Planning Services

Arun District Council

OBJECTION — Application WA/68/26/PL: Construction of a single dwelling, with garage outbuilding and associated works, The Greenway, West Walberton Lane, Walberton BN18 0QS (resubmission of withdrawn WA/33/26/PL)

Location Plan

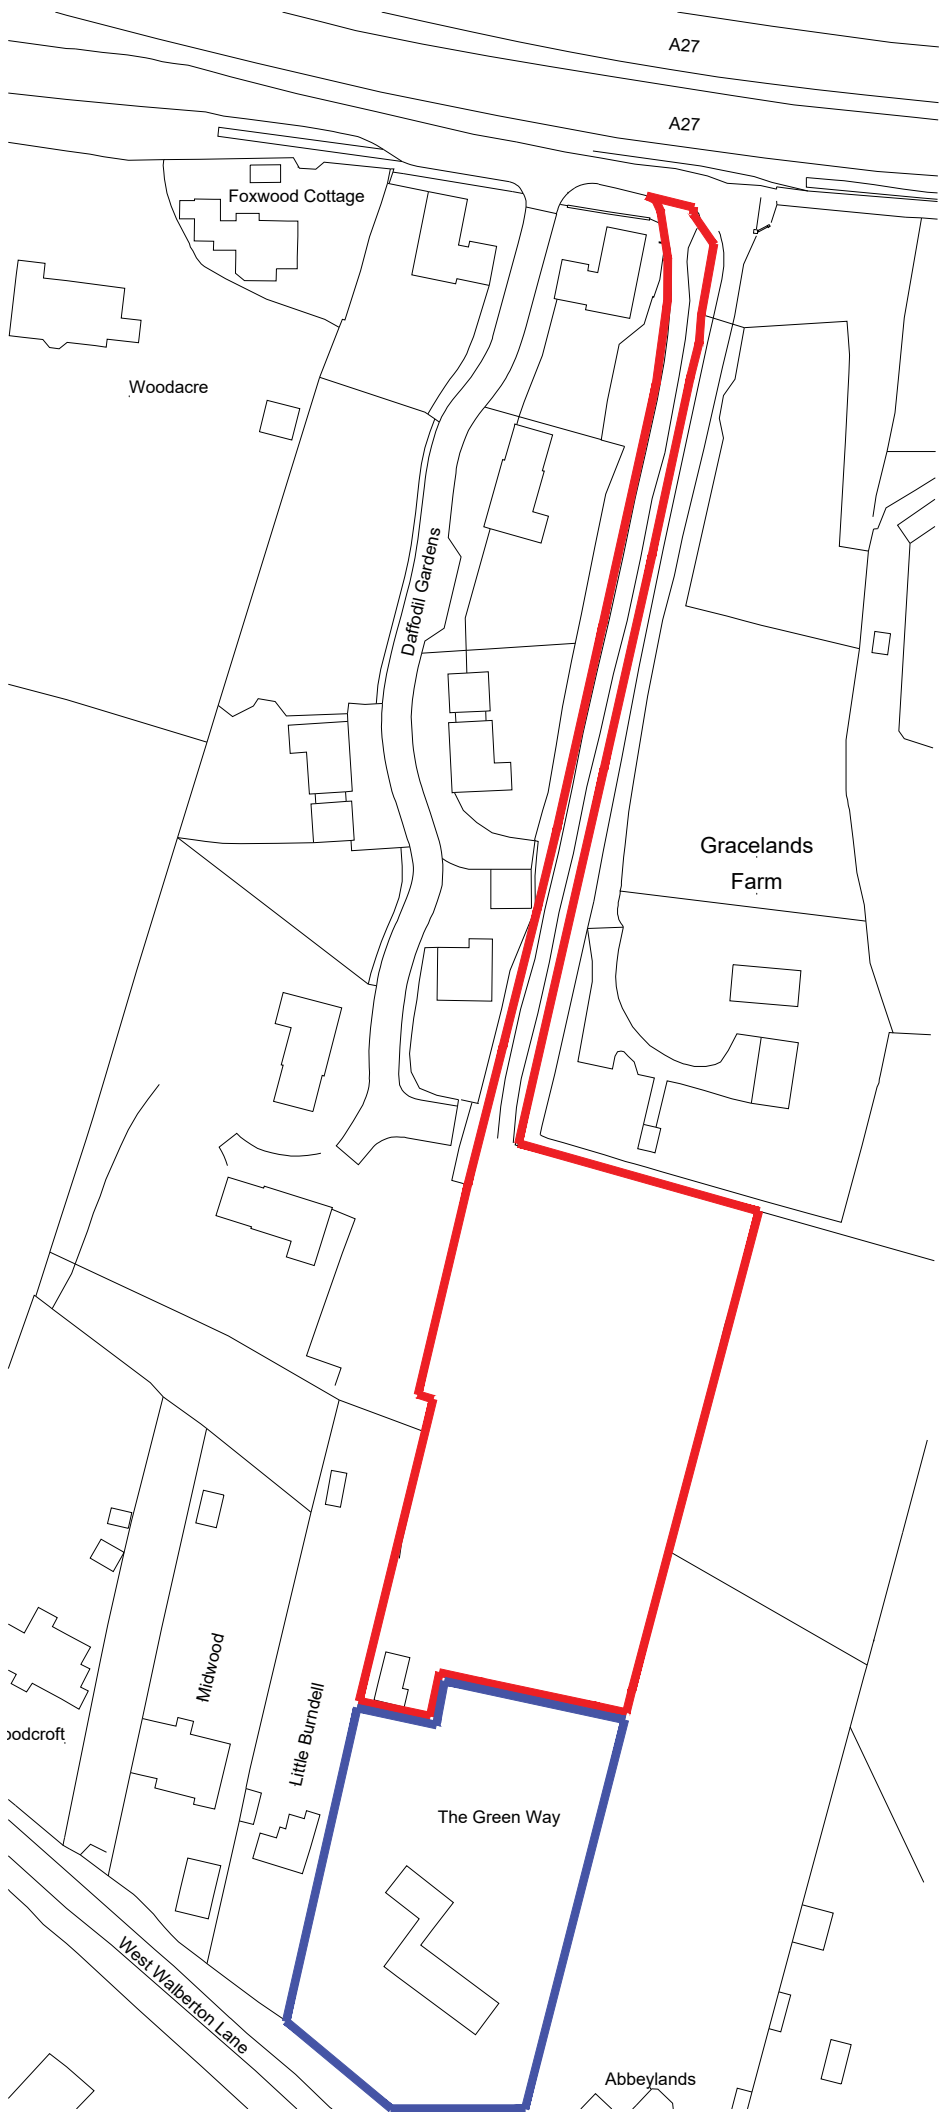
calculations survive. **I ask the Council to measure the red-line area independently, to put the discrepancy to the applicant, and to state on the record which figure is correct and what consequently falls away.**

Proposed Garage Floor Plans

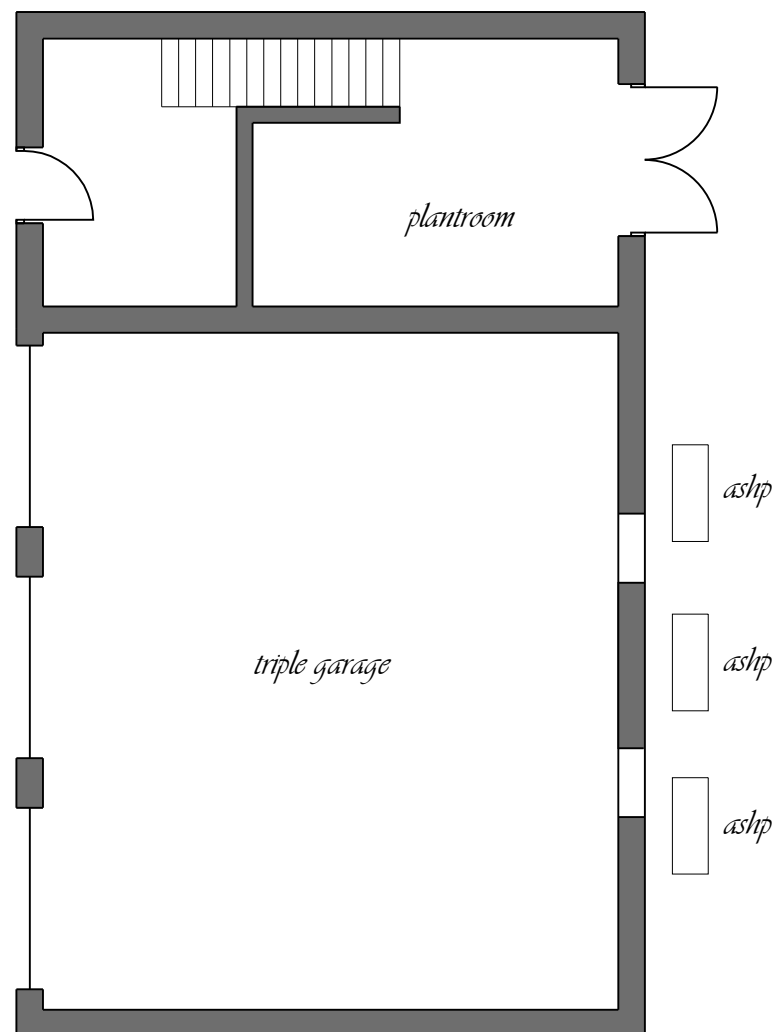
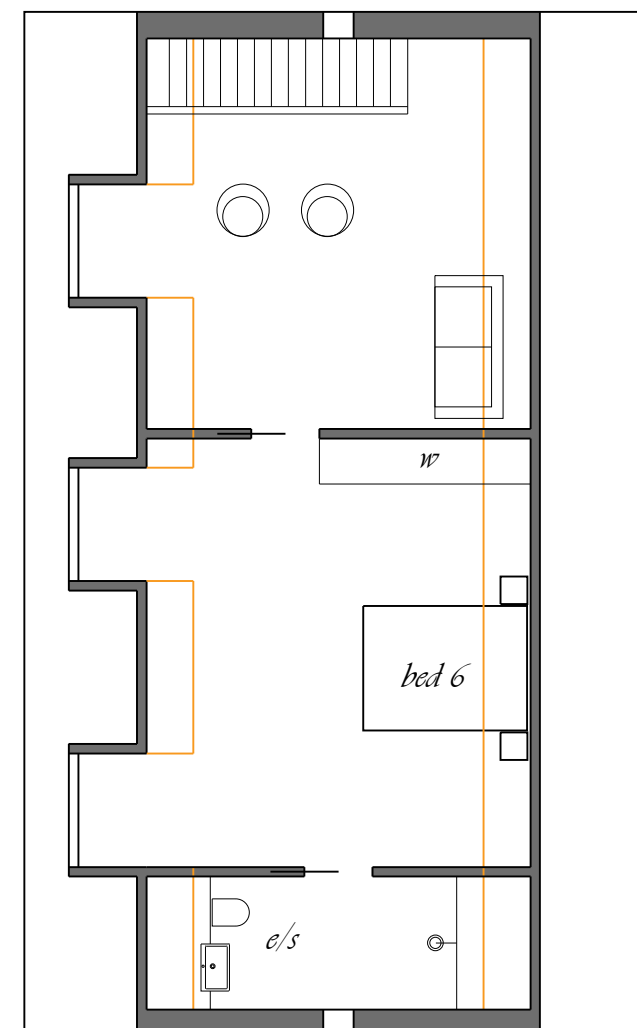
- A dwelling of two+ storeys plus habitable loft accommodation, with a triple garage with rooms over, would be conspicuously at odds with the prevailing pattern and scale of development on West Walberton Lane, and the site neighbours at Daffodil Gardens and Arundel Road.

Fire Tender Access and Egress

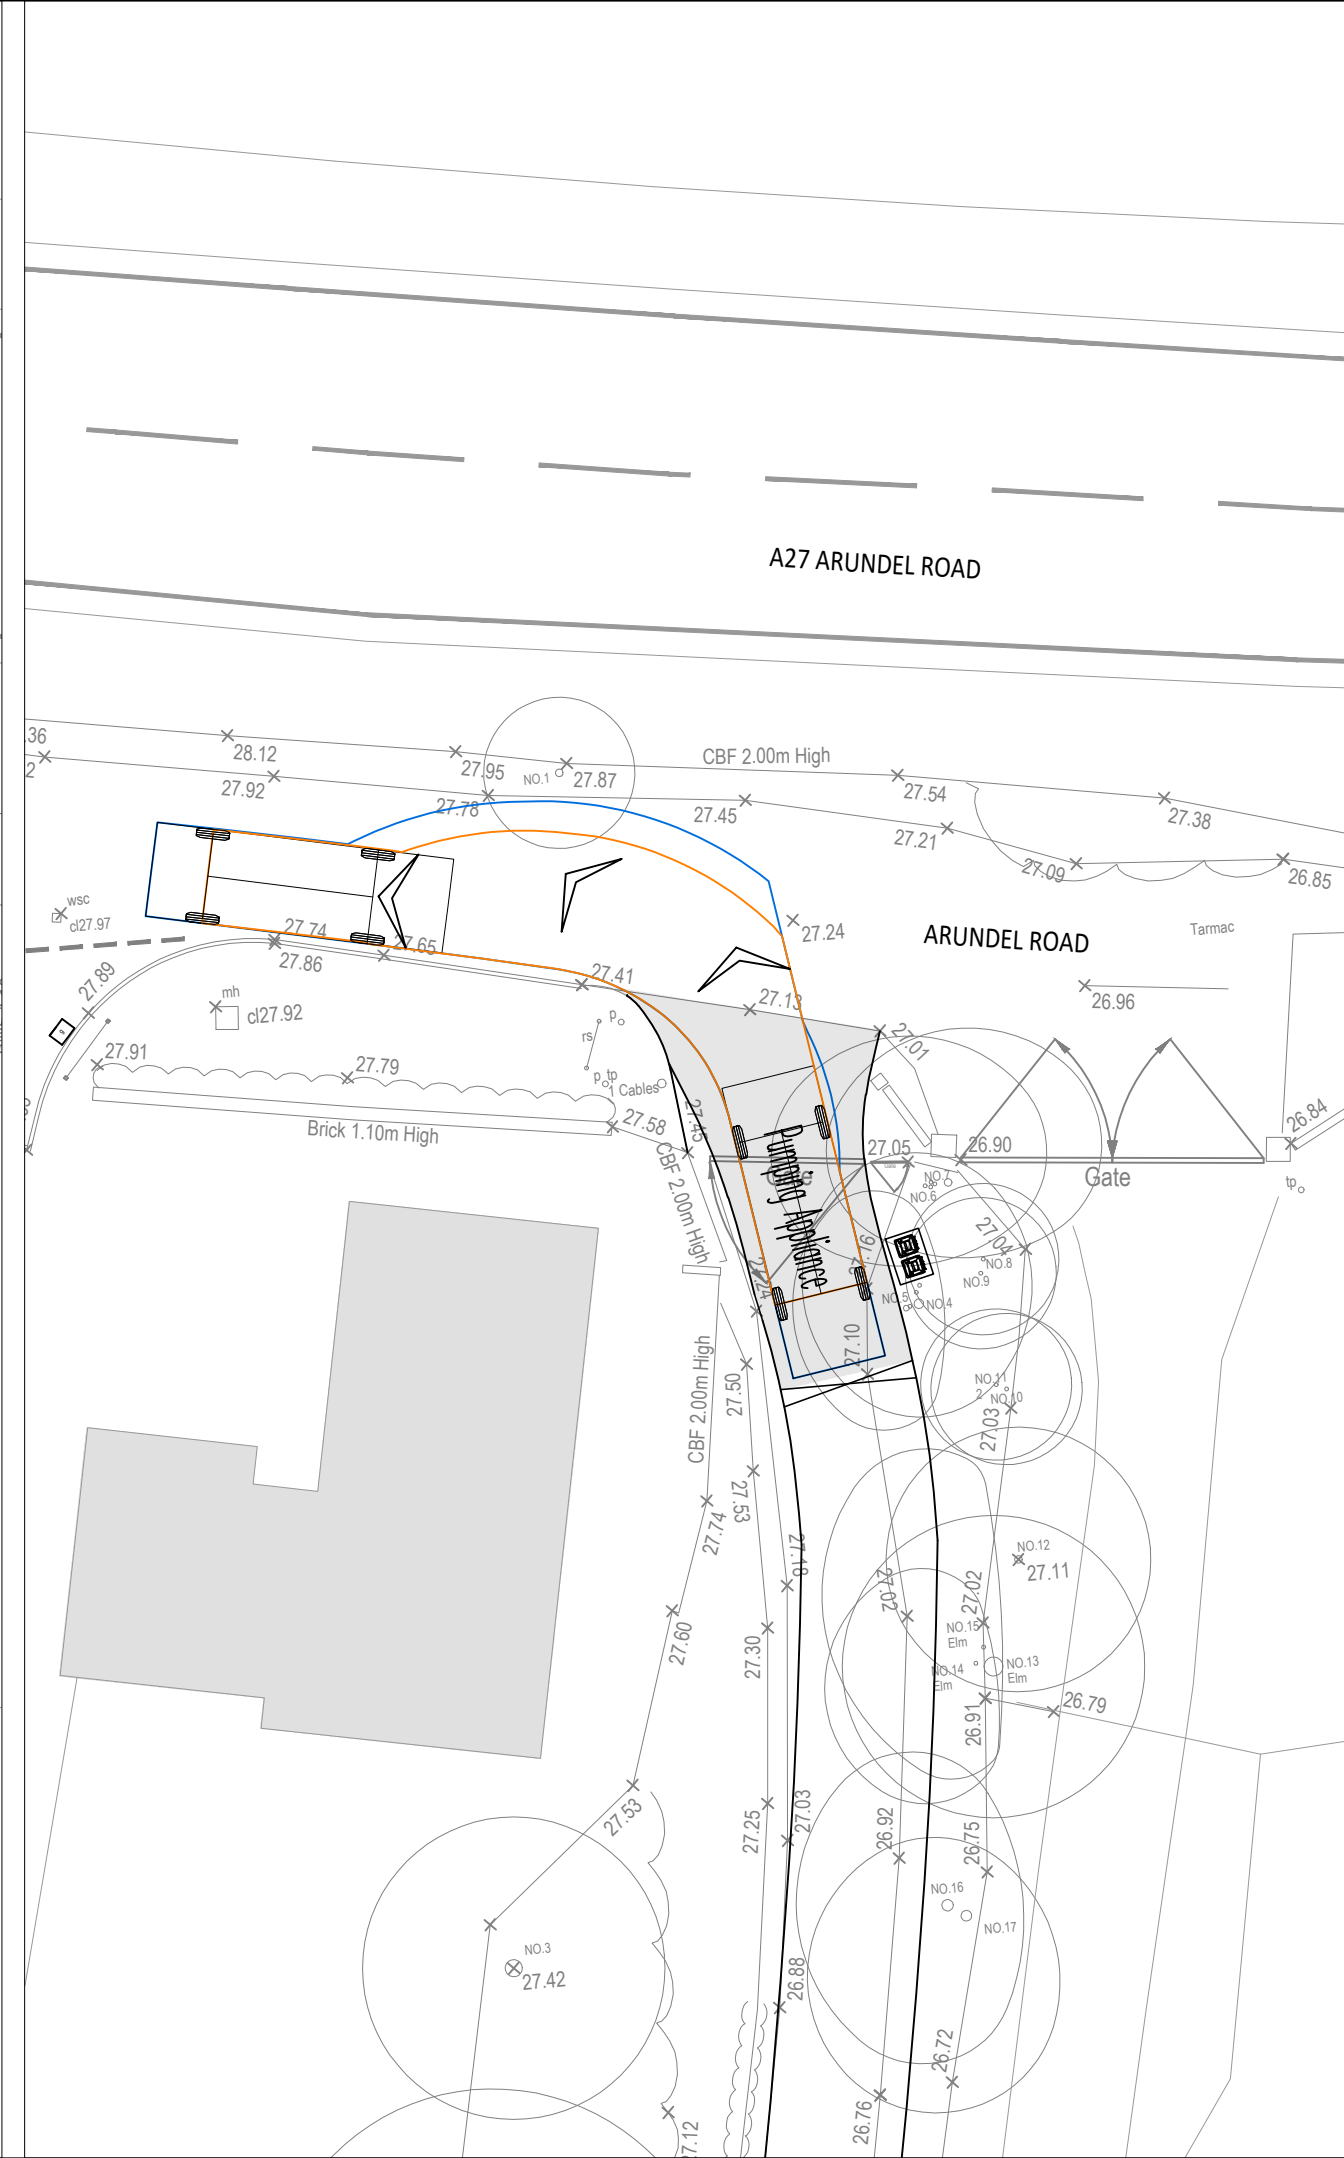
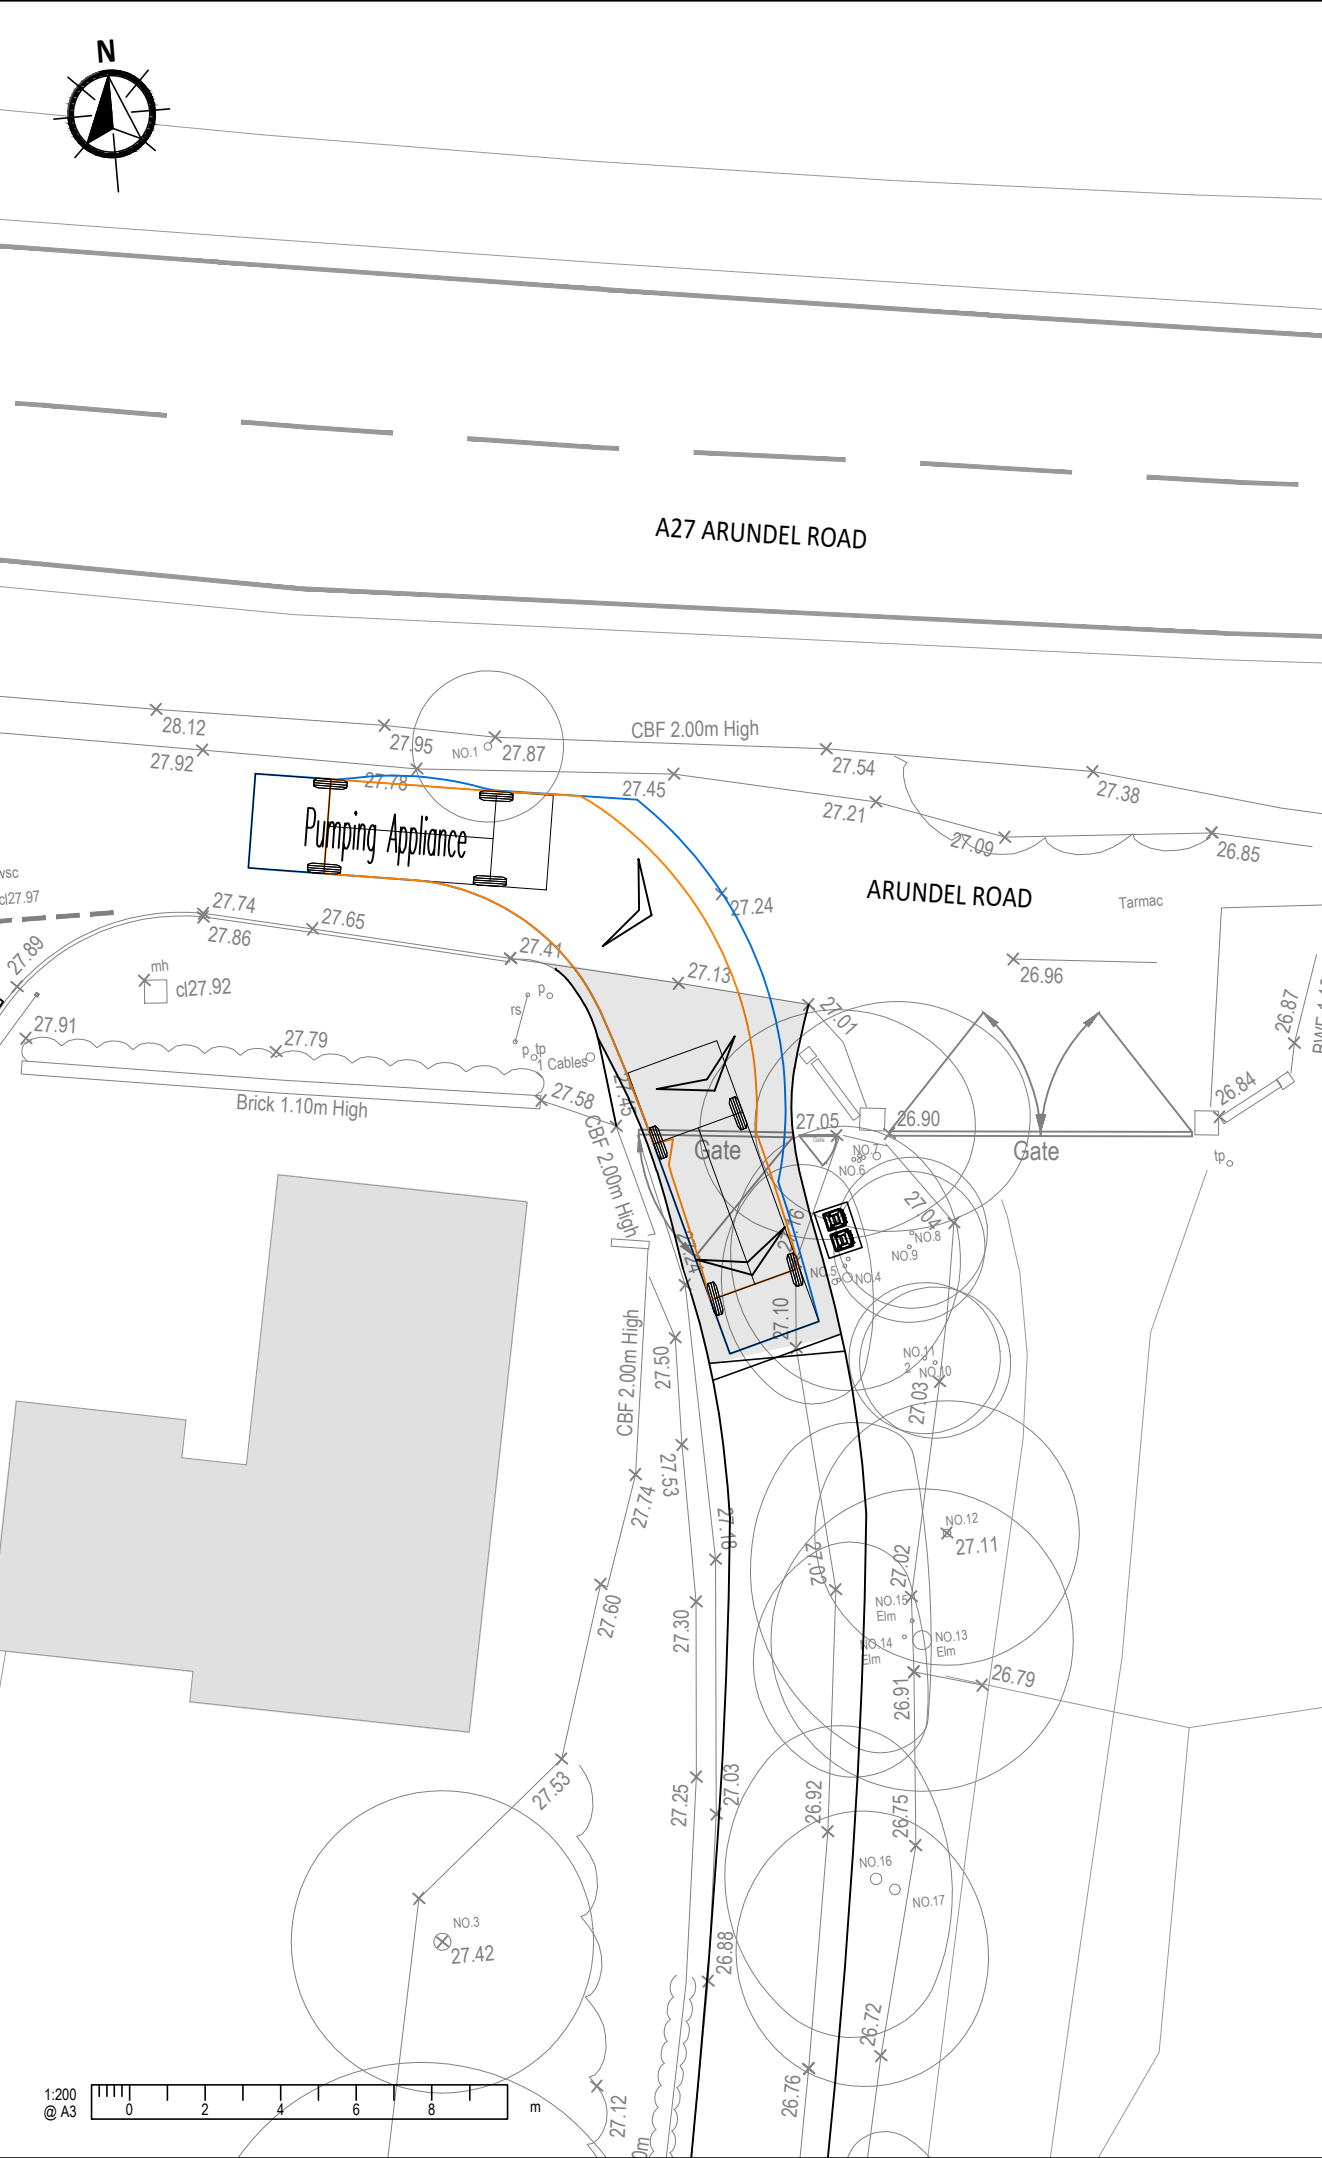
confronted with the applicant's own written admission to the contrary. I request that WSCC be re-consulted with that admission put squarely before them. If delivery of adequate visibility depends on third-party land, the notice and certificate requirements of the application fall to be re-examined and the improvement is undeliverable; a Grampian condition would be improper where there is no reasonable prospect of compliance. The c.150 m single-width unmade track must also accommodate construction traffic, refuse presentation and emergency access. It is not suitable.
